RE: **Paradise RV Park** - 10,001 Volcano Road, west of 98th St. **K08-D003**
(*Lot 3, Town of Atrisco Grant, Row 2, Unit A*)
Drainage Report & Grading Plan for Building Permit PE Stamp: **10/15/2013**

Based upon the information provided in your submittal received 10-17-2013, the above referenced report and plan cannot be approved for Building Permit.

CITY OF ALBUQUERQUE
PUBLIC WORKS DEPARTMENT
ENGINEERING DEVELOPMENT GROUP
PARADISE RV PARK
SITE PLAN FOR BUILDING PERMIT
GRADING & DRAINAGE PLAN

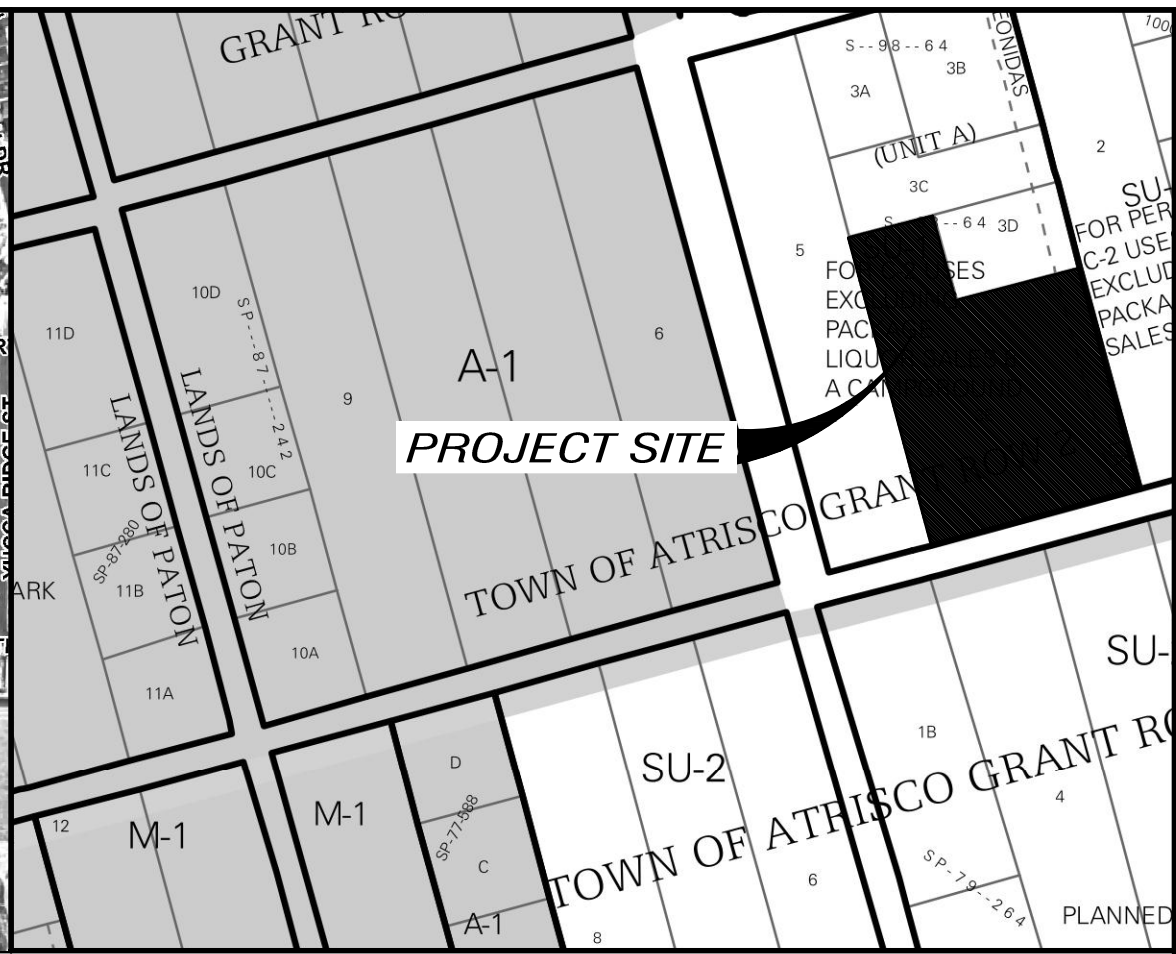
1. Please address the following drafting issues on the Grading Plan, Sheet 2 of 3:
 - a. Provide a North arrow and scale,
 - b. Label the adjacent streets,

- c. Provide survey data source, and bench mark & datum information,
 - d. Provide a Legend and Key Notes (or reference if found on another sheet)
 - e. Clearly identify R/W and Property lines

2. Label the (3:1) side slopes on the retention pond, and add a note about the design storm used for sizing, and the Design Volume required. Also, indicate Pond Bottom, Water Surface, and Pond Top elevations. These numbers will be reference information, for use when As-Built Certification is provided.

3. Show the flow path and erosion protection for the SE corner of the pond in the event of overtopping.
4. Is any berm or fencing needed on the sides of the pond to control erosion from offsite flows, and restrict access (*3:1 slopes and 12' deep on NE corner*) ?

5. Label the access easement, north of the pond, and identify if this is to be paved in Phase 1. If so, provide contours, spot elevations, and surfacing notes.

6. It appears that a retaining wall is needed on the west side of the Building pad, where grades indicate 1.5' to 5.0' differential.

7. Provide flow arrows, and contours or additional spot elevations, to clarify flow patterns in the asphalt paved areas on the northern portion of the site.

8. Hydrology requests that new development provide Low Impact Development (LID) features for water harvesting effects. It is suggested that the multiple, Landscape Areas shown between parking spaces be depressed to intercept rain that falls on them, and detain or retain developed runoff crossing the parking area. The landscaped areas at the south and east edges of the site could also be depressed for similar benefit, with curb openings from Basin 102 to Basin 104, and from 103 to 105. Provide typical sections to show these details. Typical details should anticipate the proposed, future asphalt surfacing of the parking areas, including curb openings or depressions as needed to intercept runoff.

10. To clarify your proposed design, please include flow arrows and design flow rates on the On-site Drainage Basin map, where onsite and off-site flows cross basin boundaries. Also, summarize on the plan where street flows enter and are intercepted by the proposed storm drainage systems. This will expedite review of your resubmittal, as well as Work Order plan review and Phase 2 design review.
